**Re: 657 - 769 Mamre Road, Kemps Creek (SSD 9522 MOD 2)
NSW Planning Industry & Environment – Letter dated 24 December 2021**

Further to your request we are pleased to provide our response to the items raised by NSW Planning Industry & Environment (DPIE), in their information request letter dated 24 December 2021.

**Kemps Creek Warehouse, Logistics and Industrial Facilities Hub (SSD-9522-Mod-2)
Request for additional information**

DRAWING TITLE
ROAD LONG SECTIONS AND
TYPICAL SECTIONS-SHEET 2
DRAWING NO
C013362.00-DA04
ISSUE B

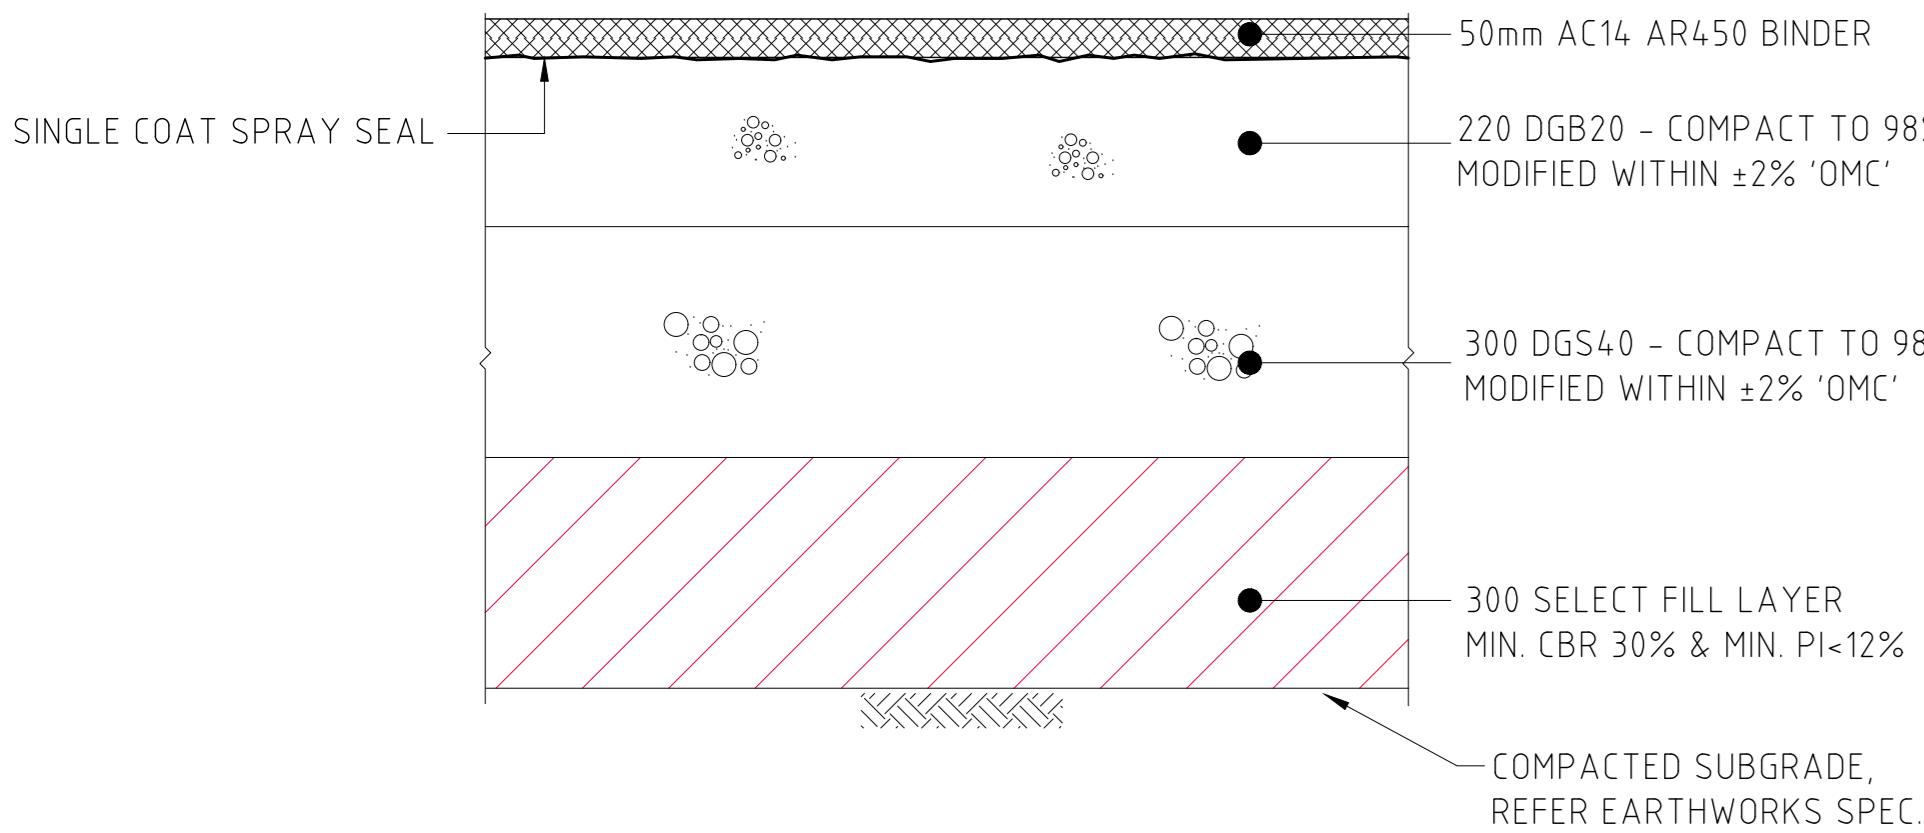
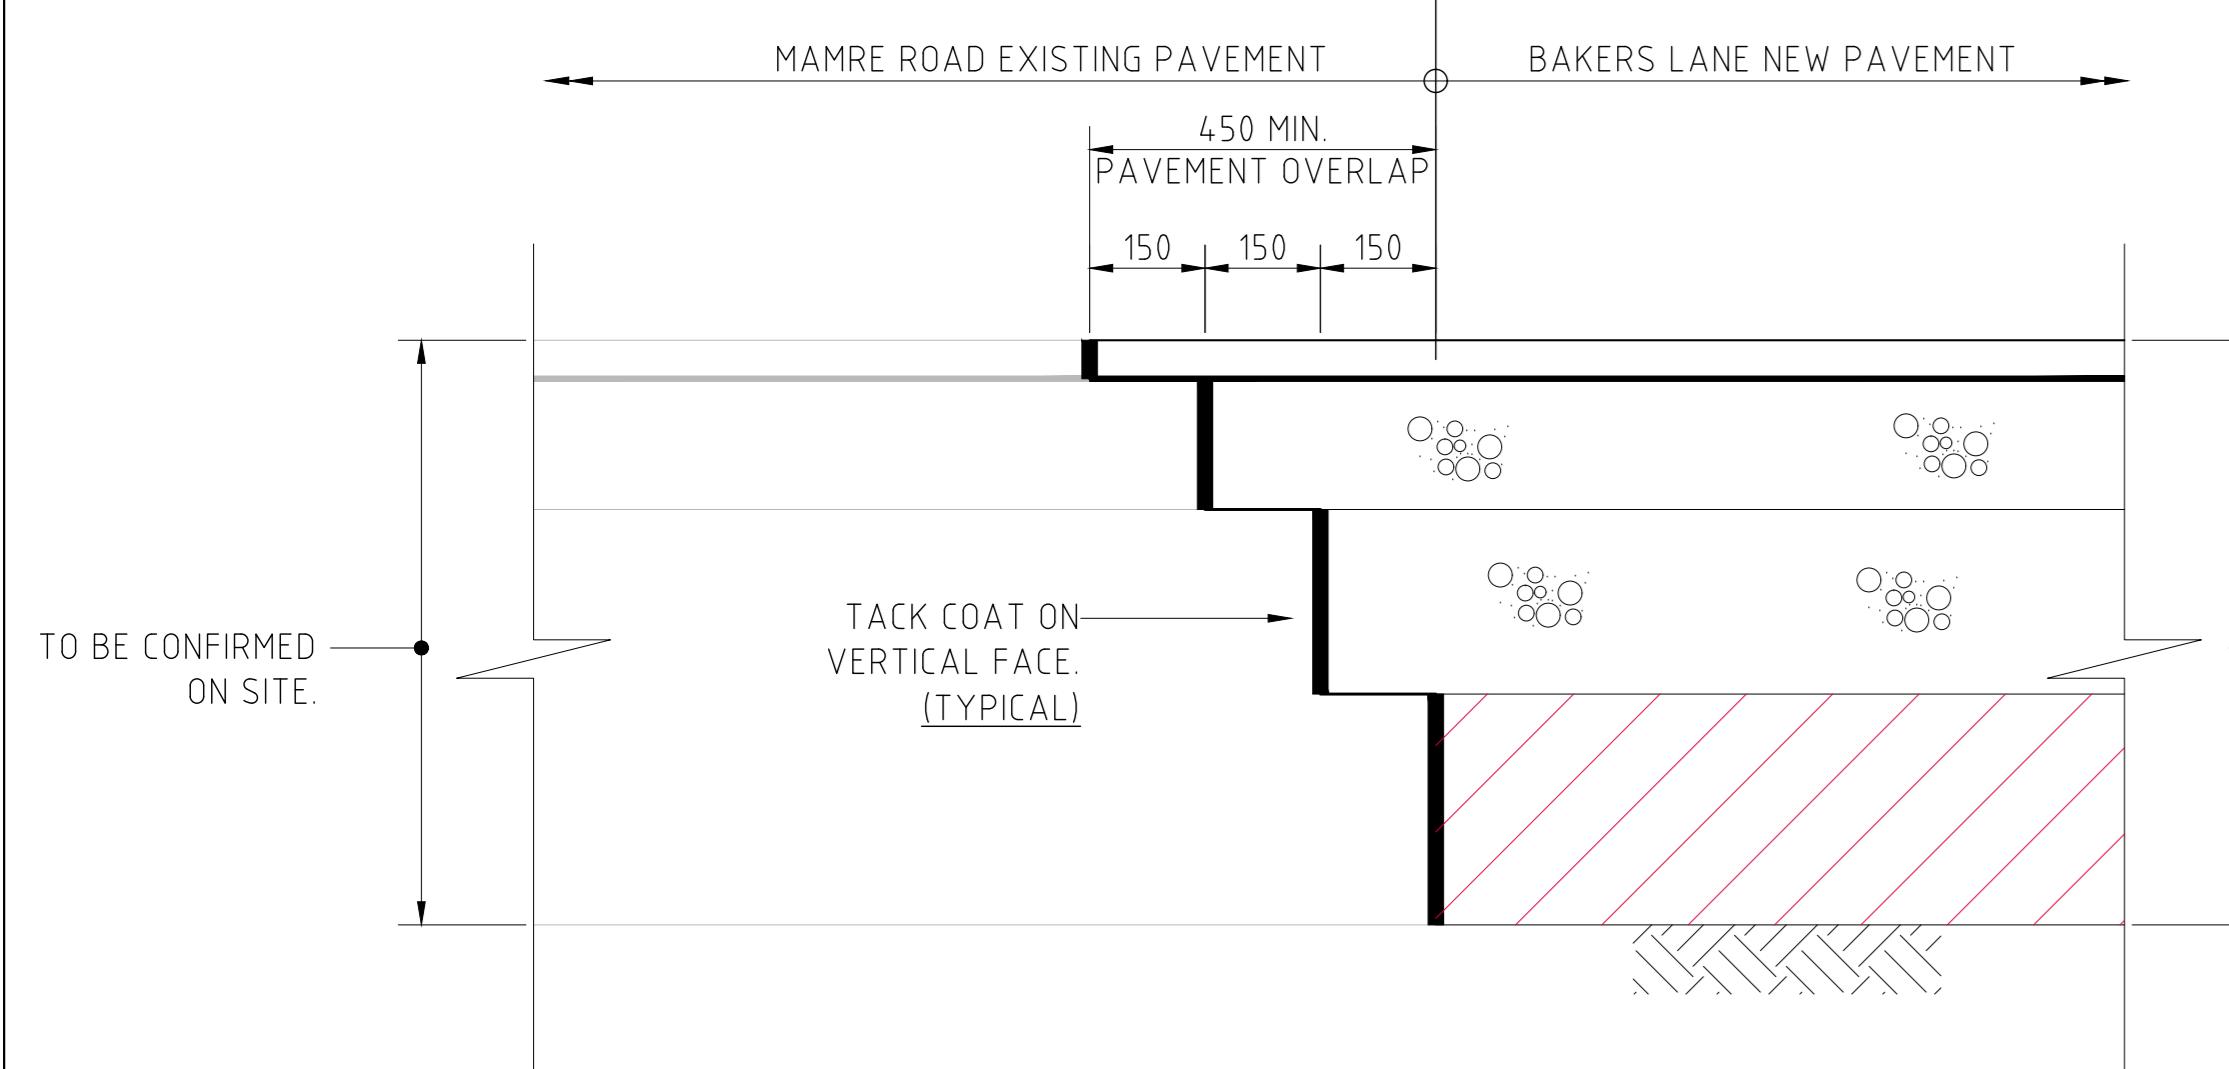
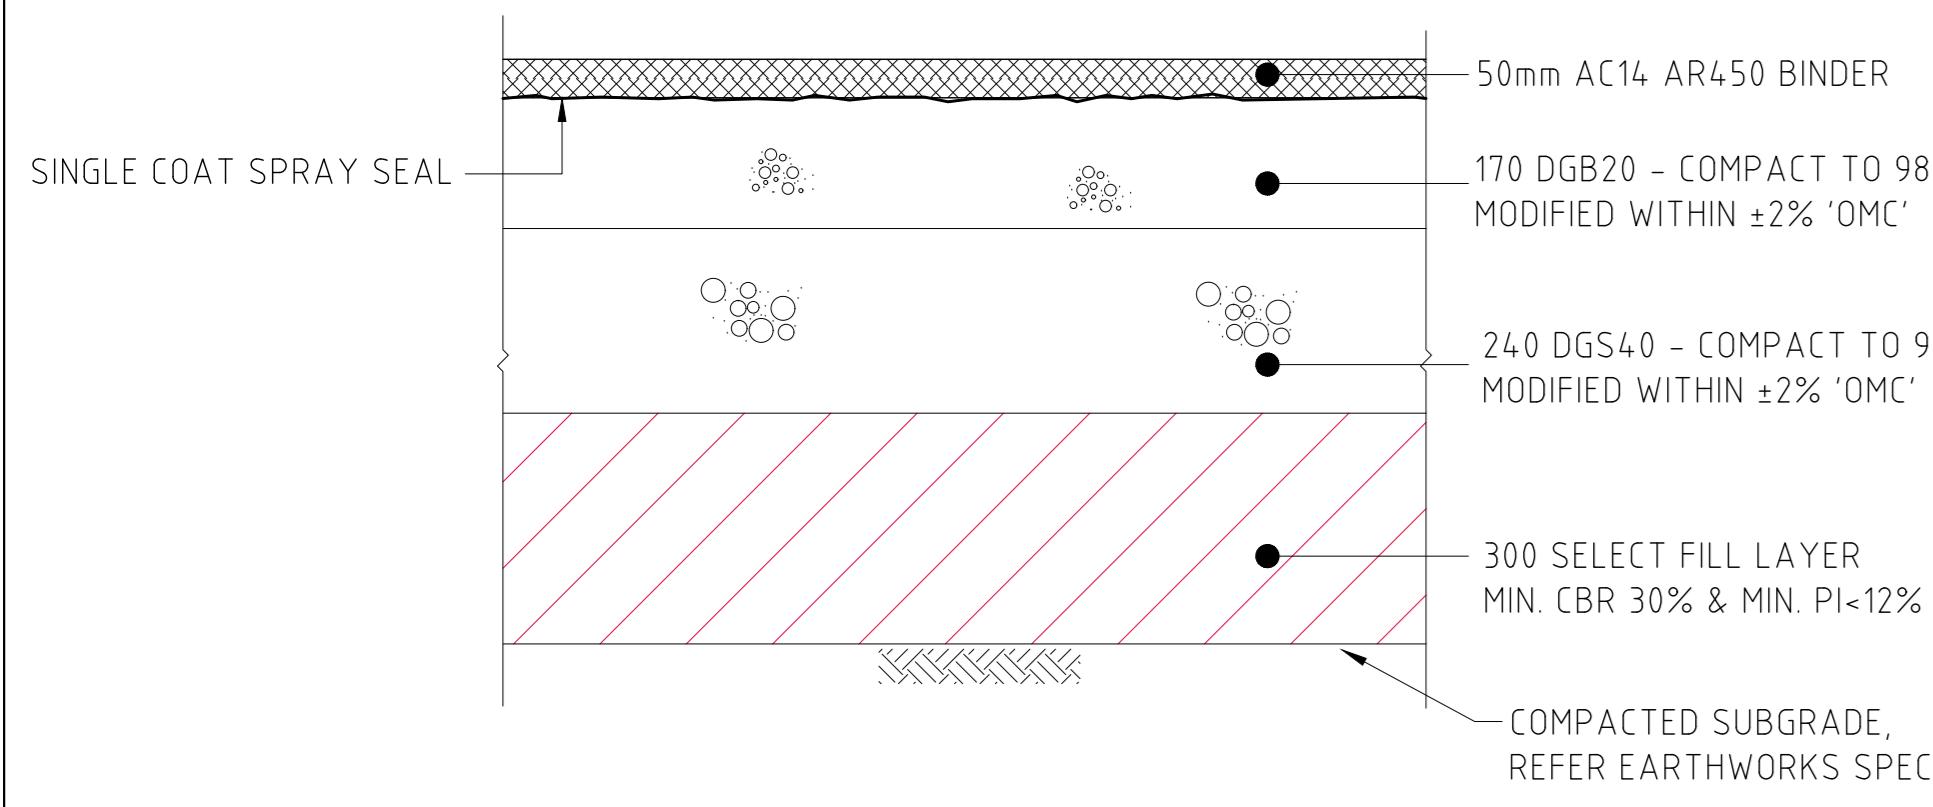
- The proposed amendments to the road reserve, as summarised in the table titled 'Estate Road Cross Section per SSD 9522' on page 14 of the Modification Report dated 19 October 2021, have not been modified in the civil drawings. Drawing CO13362.00 – DA 04 Issue B does not depict the modified road widths (Section 2). This error is carried into other civil drawings (CO13362.00 – DA08 Issue C) used in the swept path analysis. These errors need to be addressed and the swept path analysis reassessed with the agreed road widths.

No.	Item and Response
1)	<i>The proposed amendments to the road reserve, as summarised in the table titled 'Estate Road Cross Section per SSD 9522' on page 14 of the Modification Report dated 19 October 2021, have not been modified in the civil drawings. Drawing CO13362.00 – DA 04 Issue B does not depict the modified road widths (Section 2). This error is carried into other civil drawings (CO13362.00 – DA08 Issue C) used in the swept path analysis. These errors need to be addressed and the swept path analysis reassessed with the agreed road widths.</i> <u>Response</u> We provide updated letter and sectional drawing to confirm the modelled swept paths and agreed road widths. We note the road widths assessed are consistent with the Final Mamre Road Precinct DCP, noting Access Road 2 depicts a modified Industrial road with an additional 1.2m wide central median as requested by Penrith City Council. The report has been revised to confirm the road dimension for the Industrial Road Type 1, and cul-de-sac cul-se-sac as per the dimensions reflected on Section 2 & 3 of drawing CO13362.00-DA04 Issue C. The road cross section and road layout assessed (including the turning paths on drawing CO13362.00-DA08 Issue C) are consistent with the noted amended Table 2 as agreed with Council and the Final Mamre DCP.
